WEST SUSSEX COUNTY COUNCIL CONSULTATION

TO:	Arun District Council FAO: Daun Johnson
FROM:	Stephen Gee WSCC - Highways Authority
DATE:	5 January 2021
LOCATION:	Tye Lane Walburton BN18 0LU
SUBJECT:	WA/93/20/PL Alternative access & emergency access along with minor highway works following WA/95/18/RES. This site is in CIL Zone 2 (Zero Rated) as other development.
DATE OF SITE VISIT:	n/a
RECOMMENDATION:	More Information / Modification
S106 CONTRIBUTION TOTAL:	n/a / £ See below for breakdown.

AVISFORD PARK ROAD

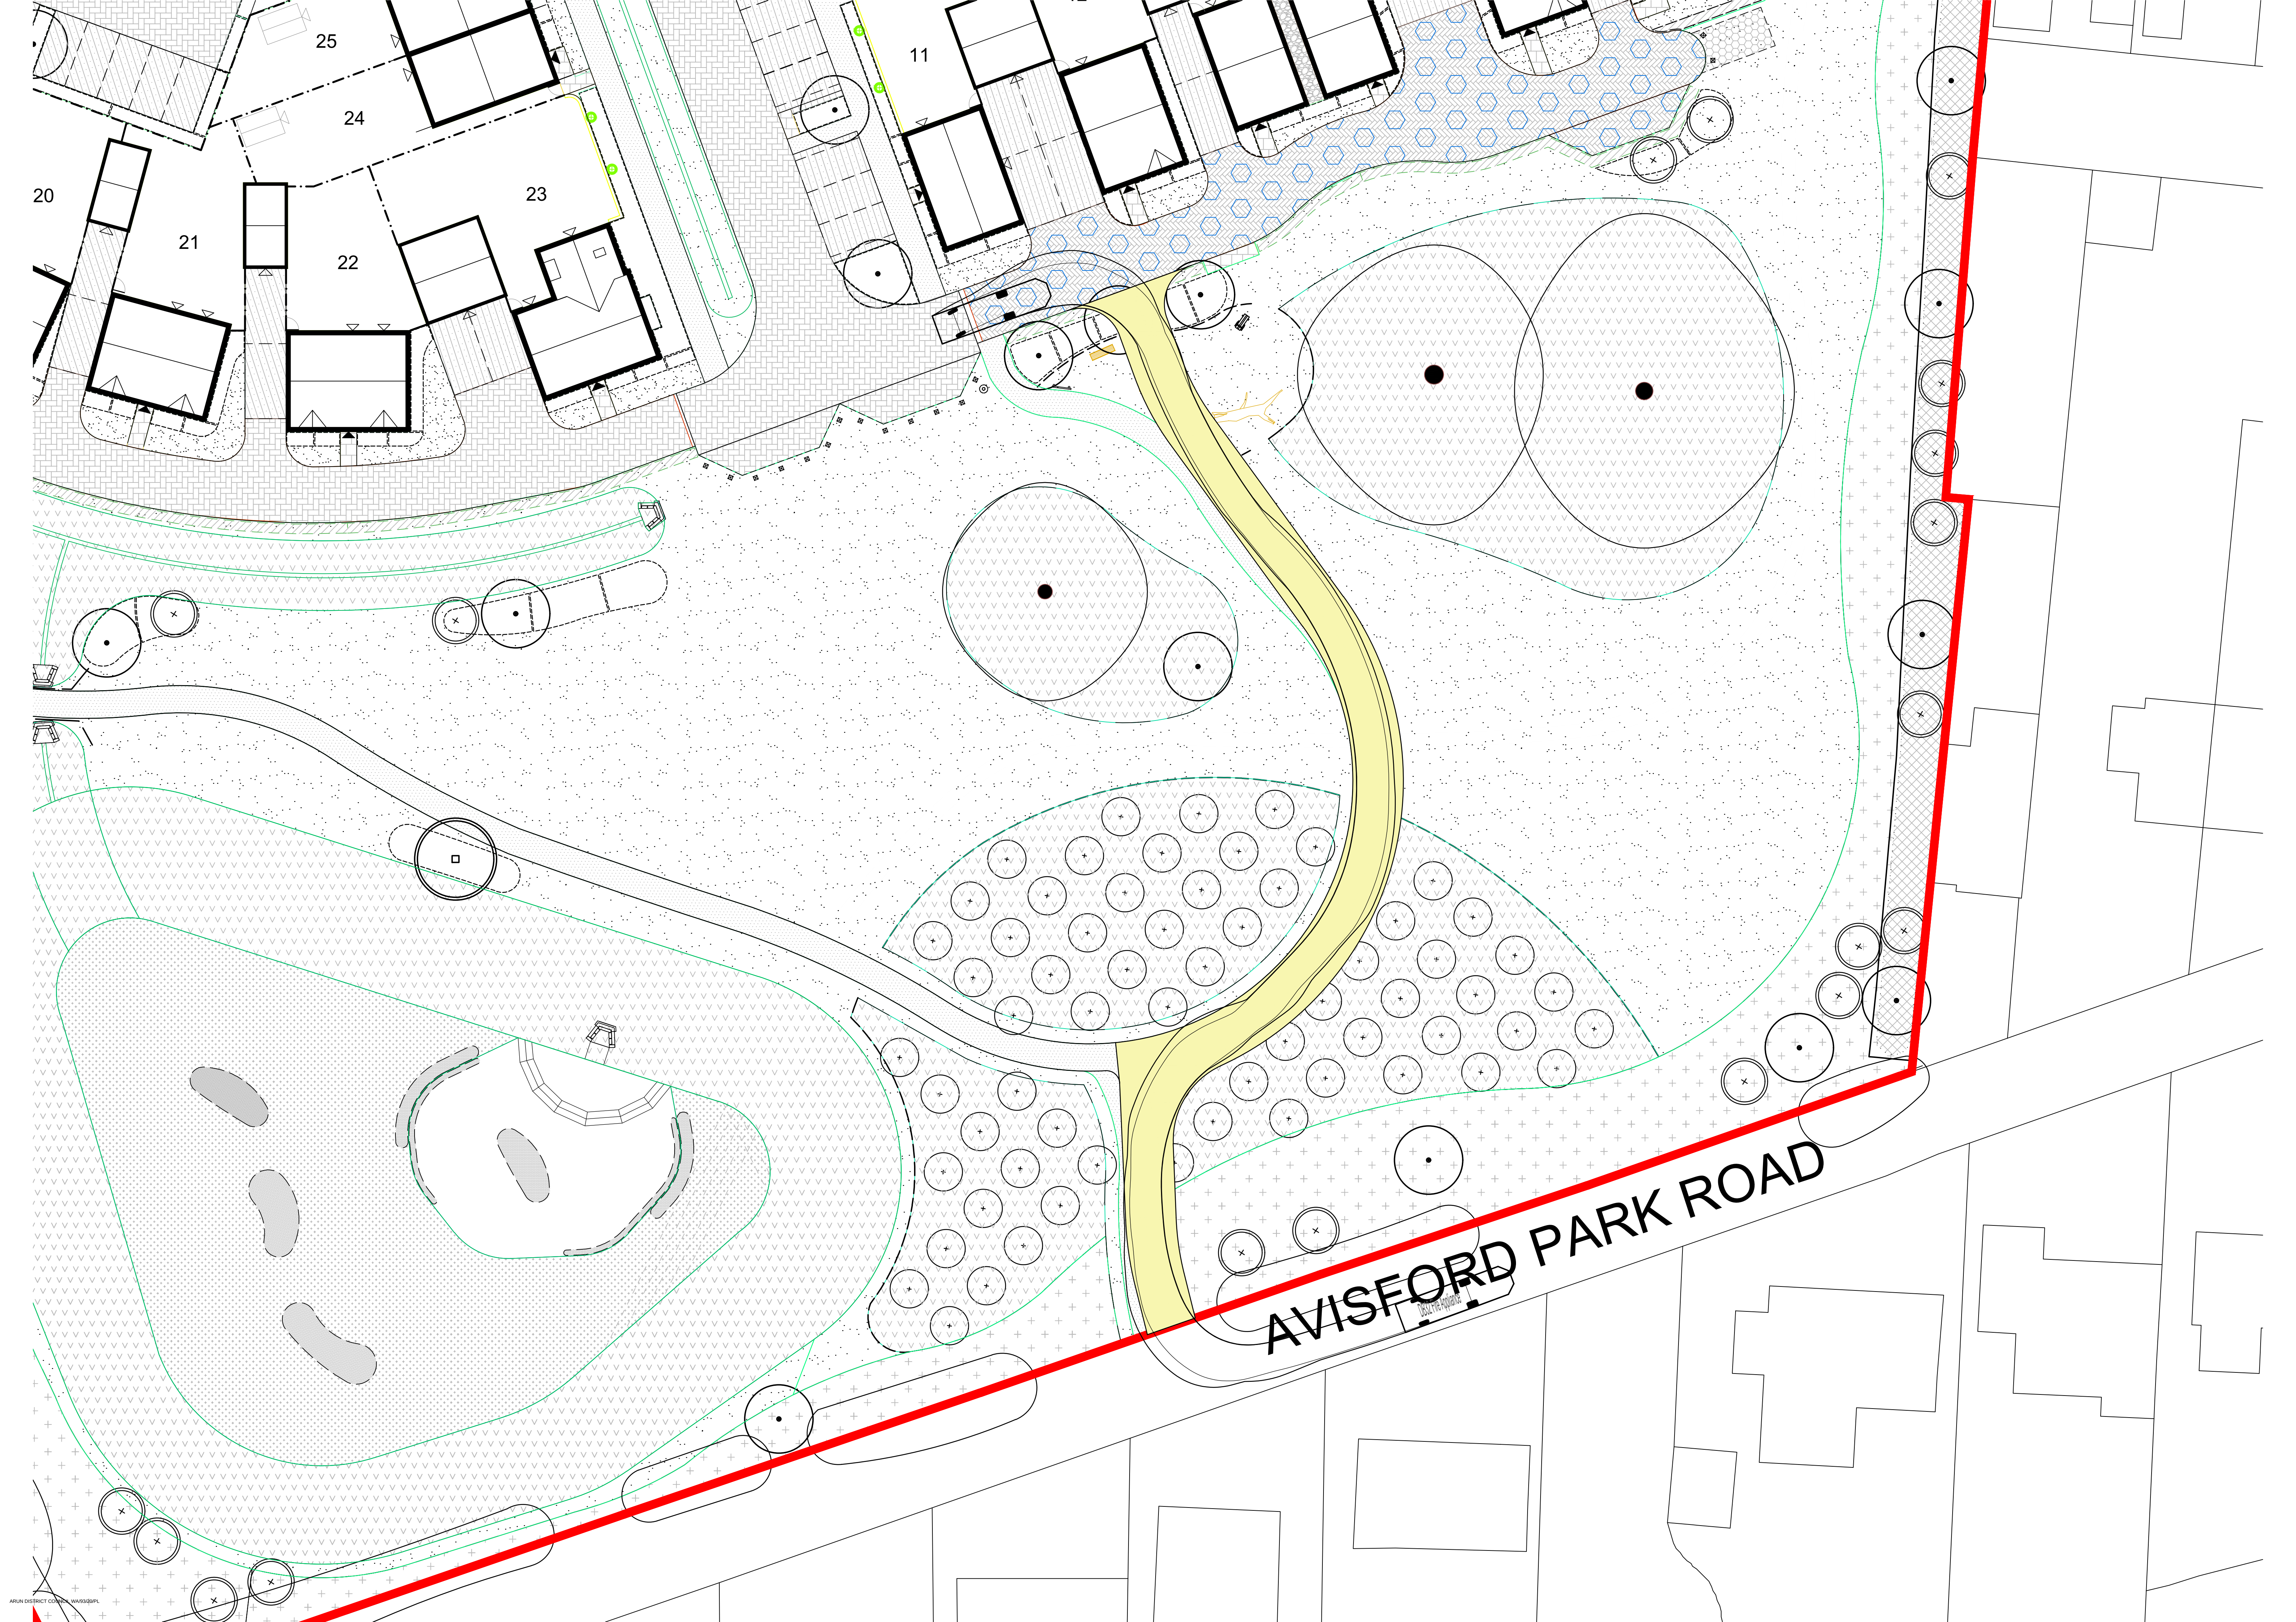
An emergency access would be provided onto Avisford Park Road of 3.7m wide and incorporate a removal bollard. The access would also be utilised by peds/cyclists as per the existing consented access arrangements. Vehicle tracking and information concerning the internal layout of the site should also be provided.

It is noted that Avisford Park Road is a private road with a PROW running along it.
